Further comments by applicant's agent in **green**, by email 04/03/2026, in response to comments by KC LLFA:

Title: Surface Water Attenuation Tank
 and External Works

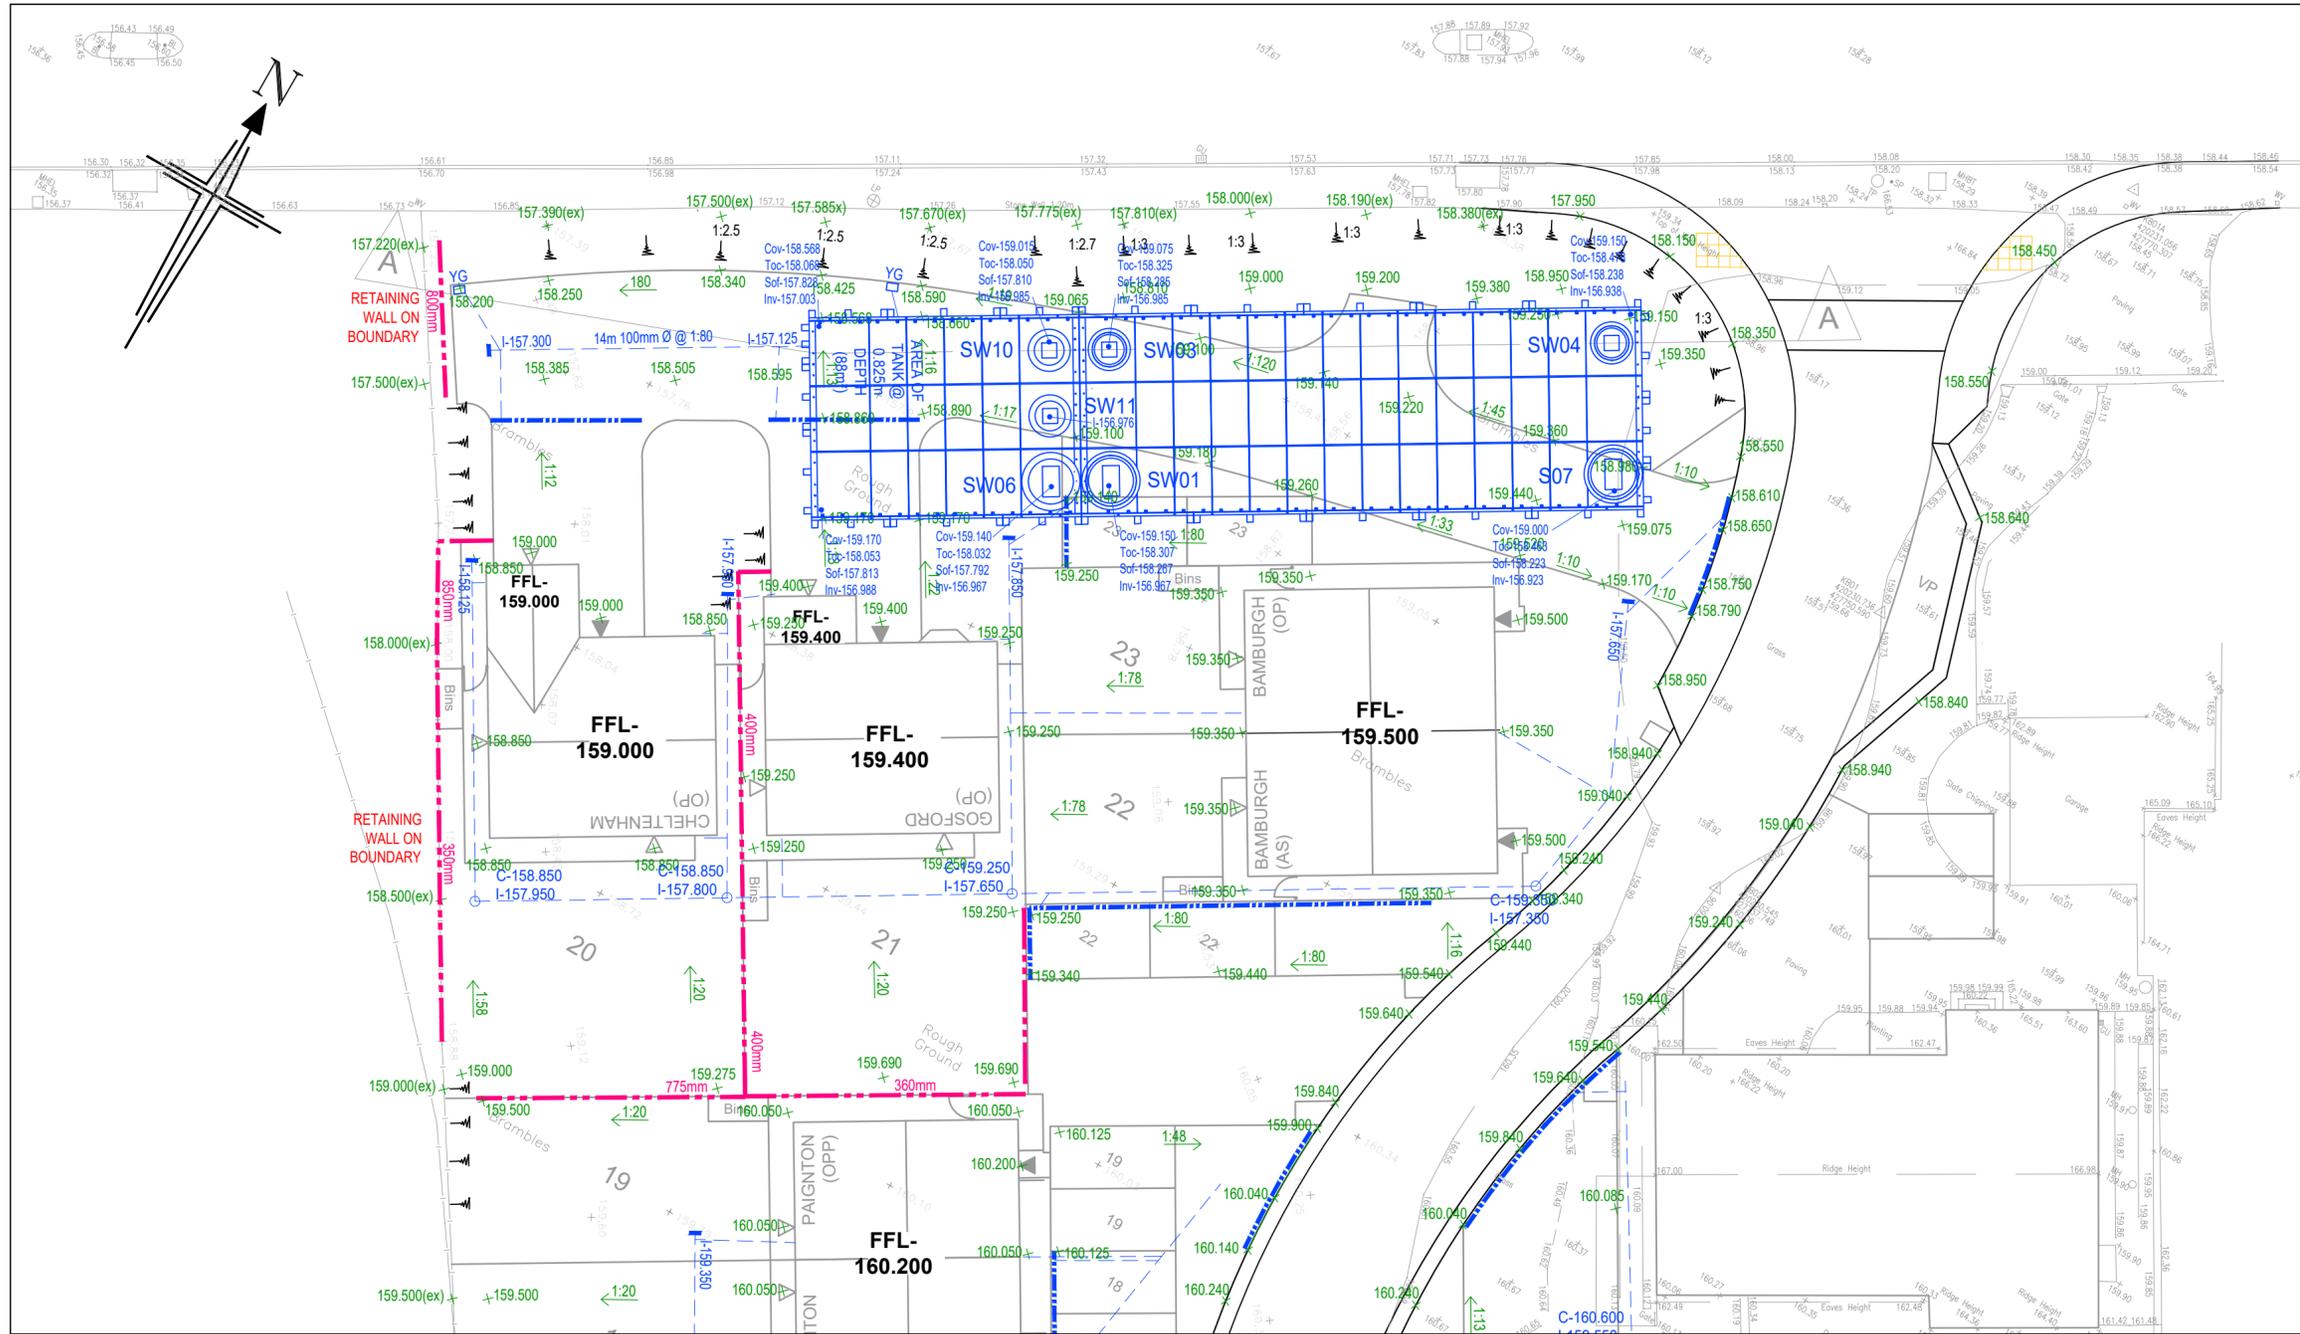
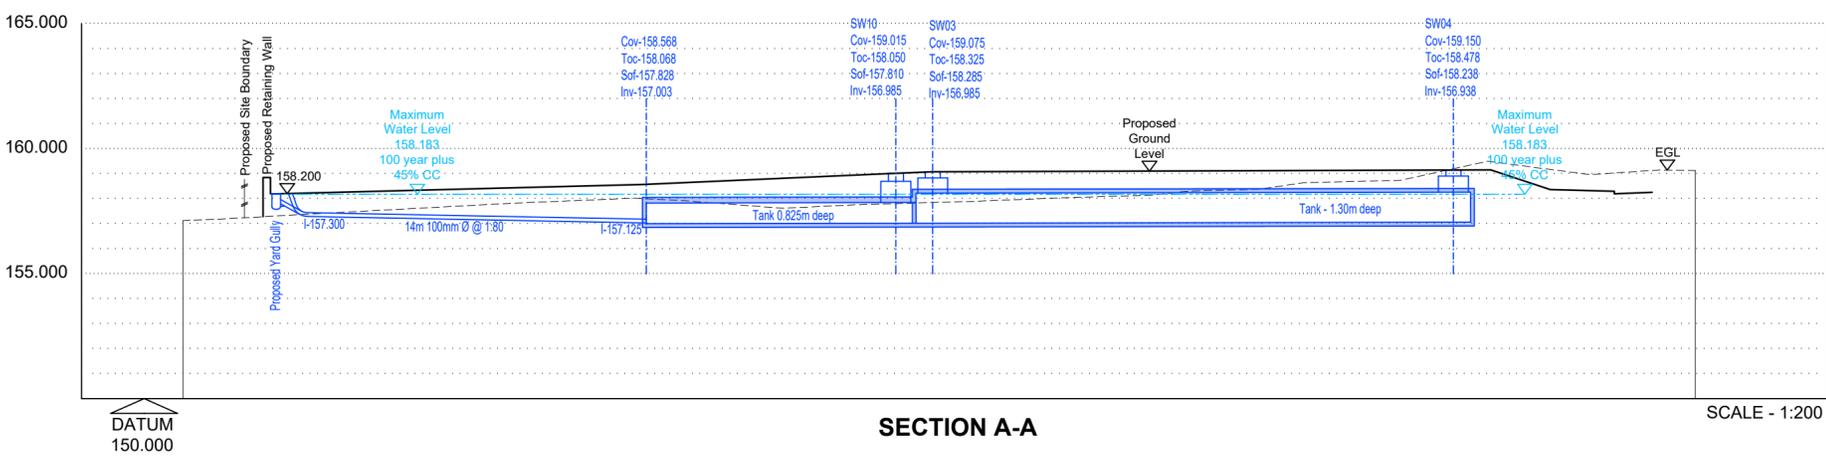
We advise the planning officer that confirmation is required that the design for the tank is FP McCann with submitted drawings, and has not been changed to crate storage which cannot be maintained as described in the report. Once this is done the condition CAN be discharged without further consultation to the LLFA”

The tank is as described and hasn't been changed.

New Surface Water Attenuation Tank FP McCann concrete system approved by Yorkshire Water under Section 104 reference S104-2024-034

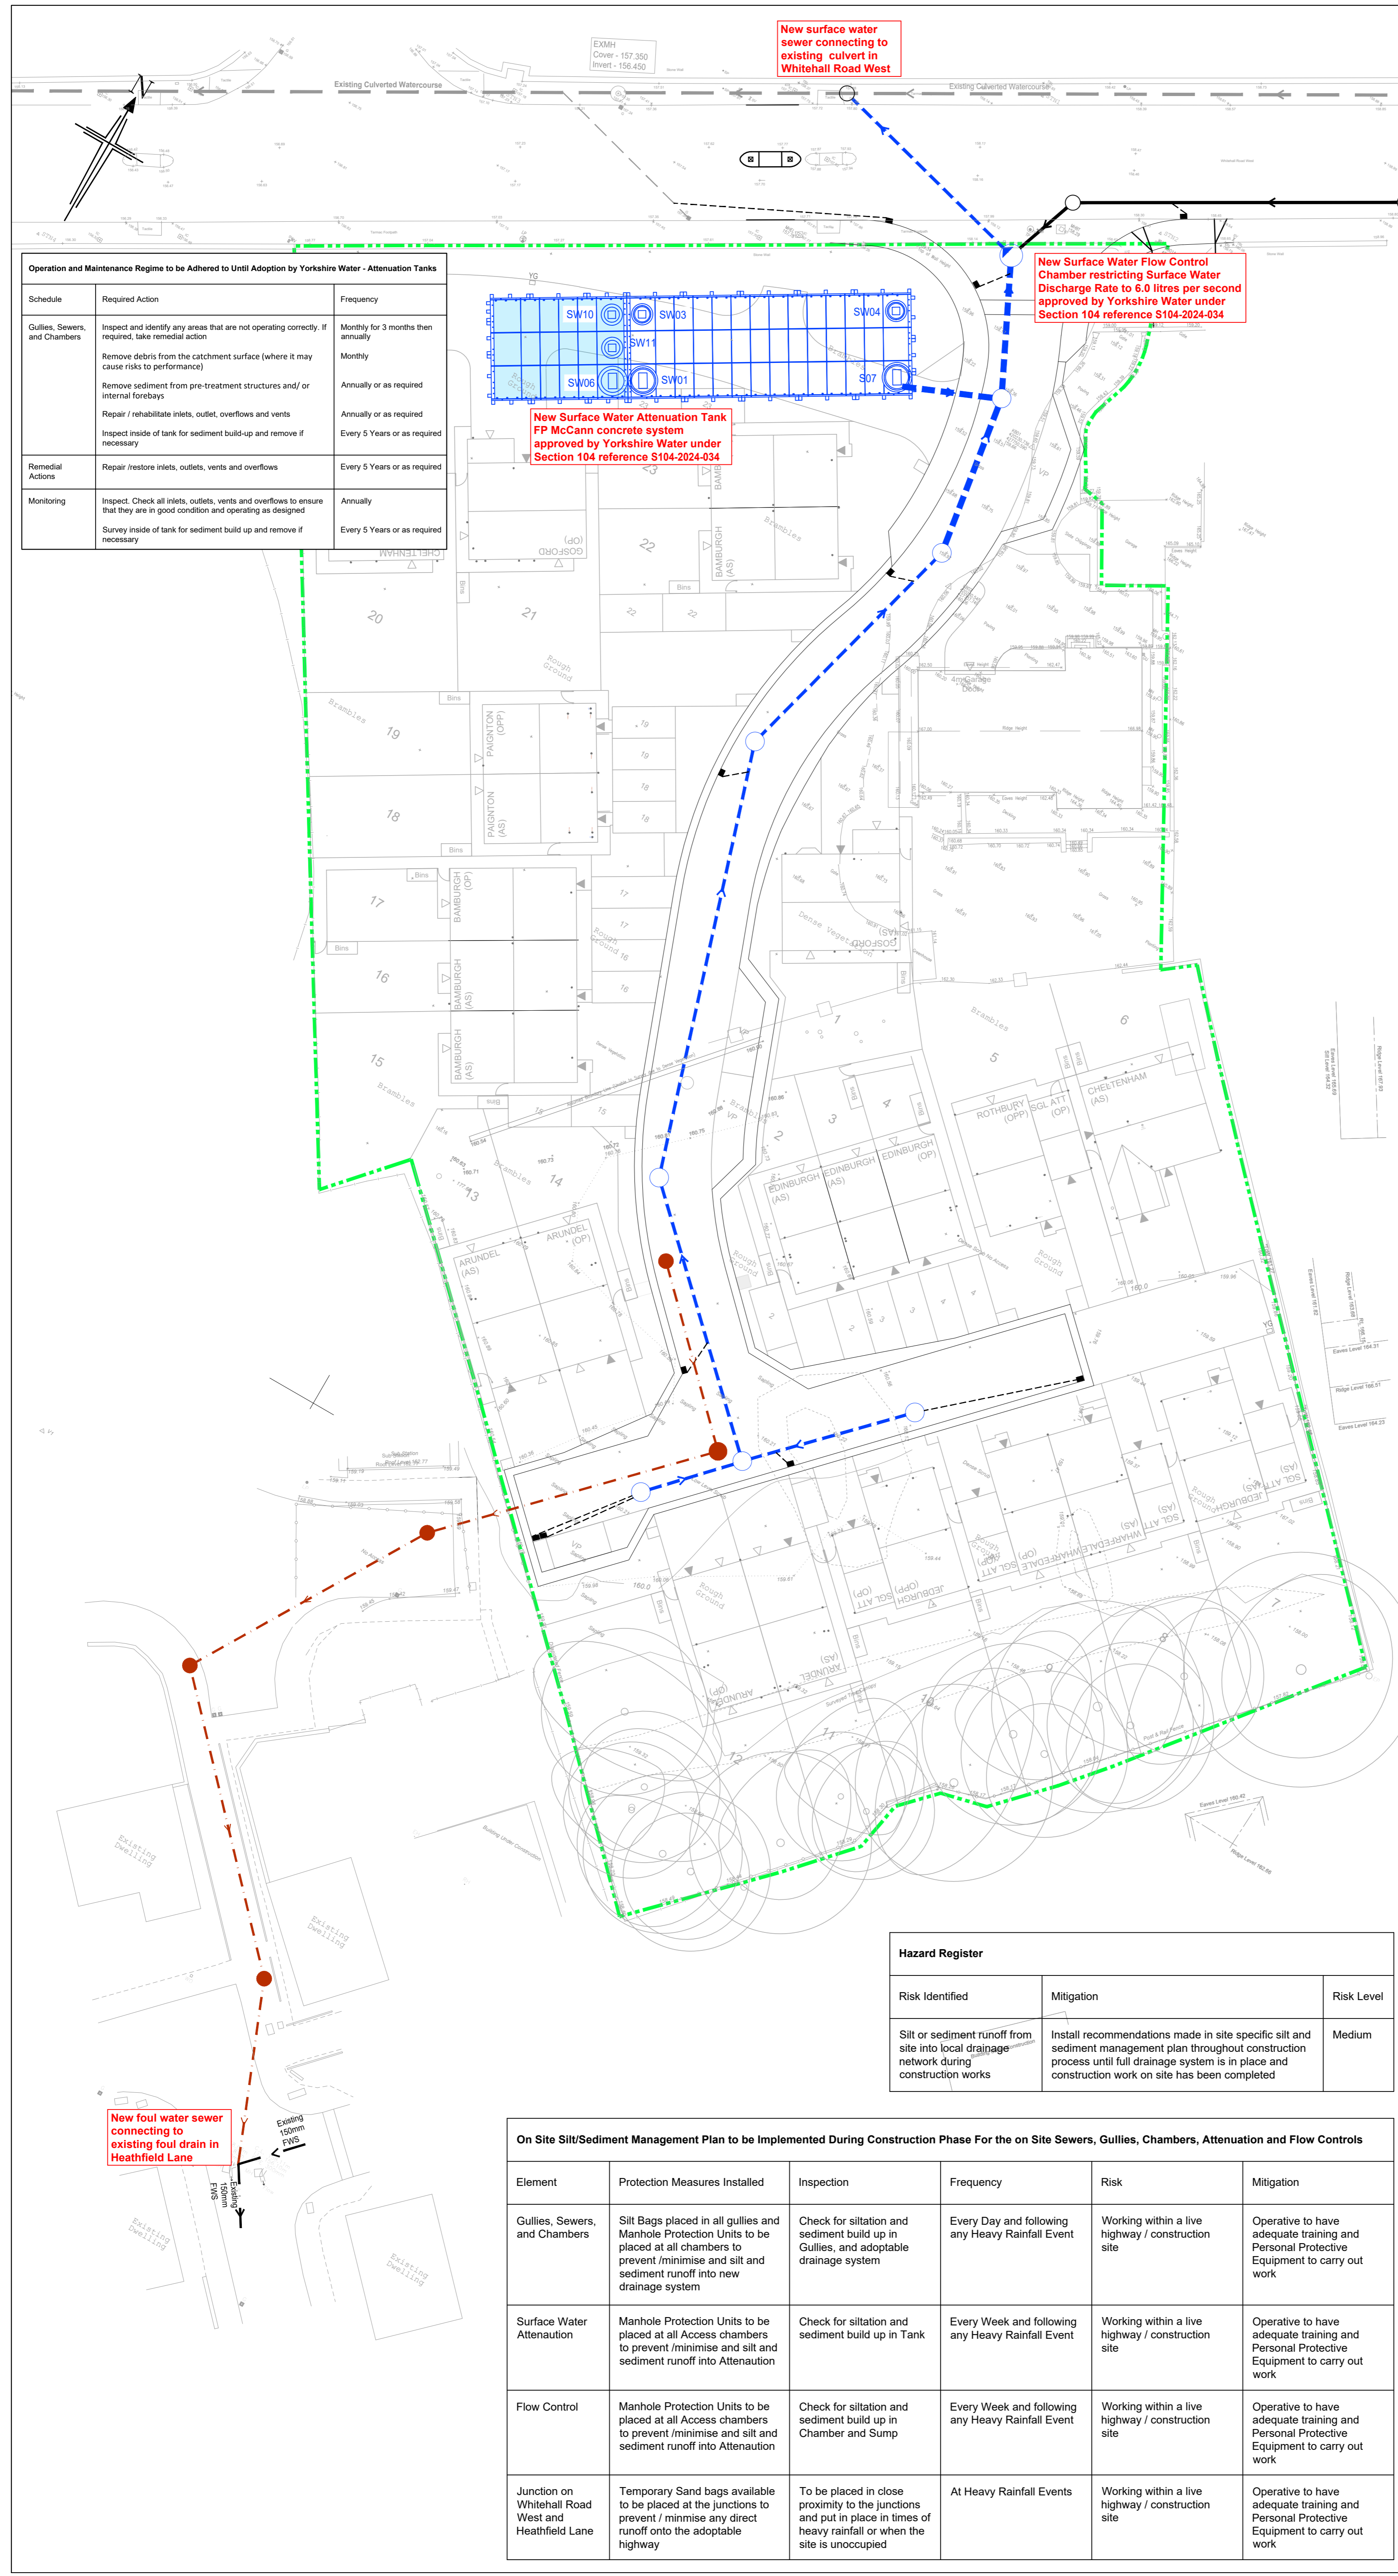
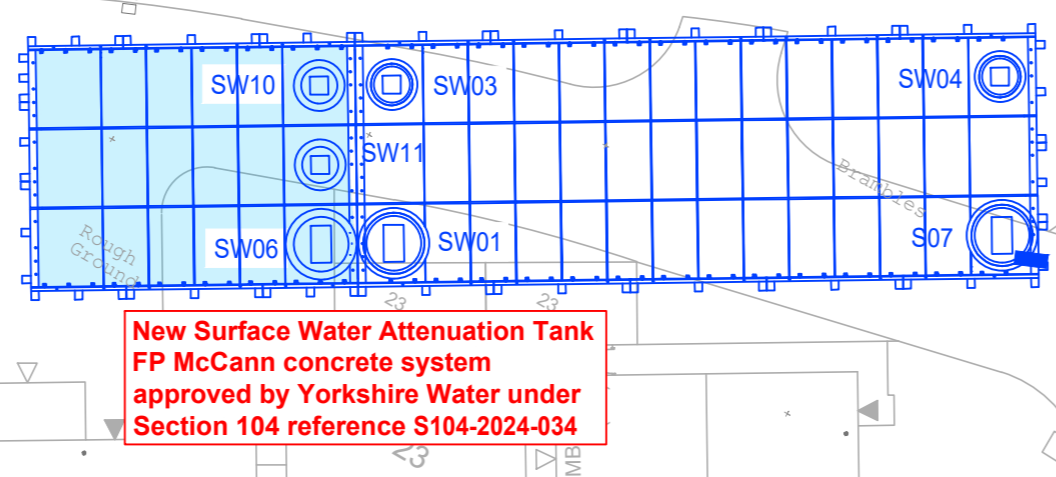
The flow control device should have a replacement of the neoprene seal if the flow control must be removed for blockages at any point in the future.

The flow control device does have replacement neoprene seals.
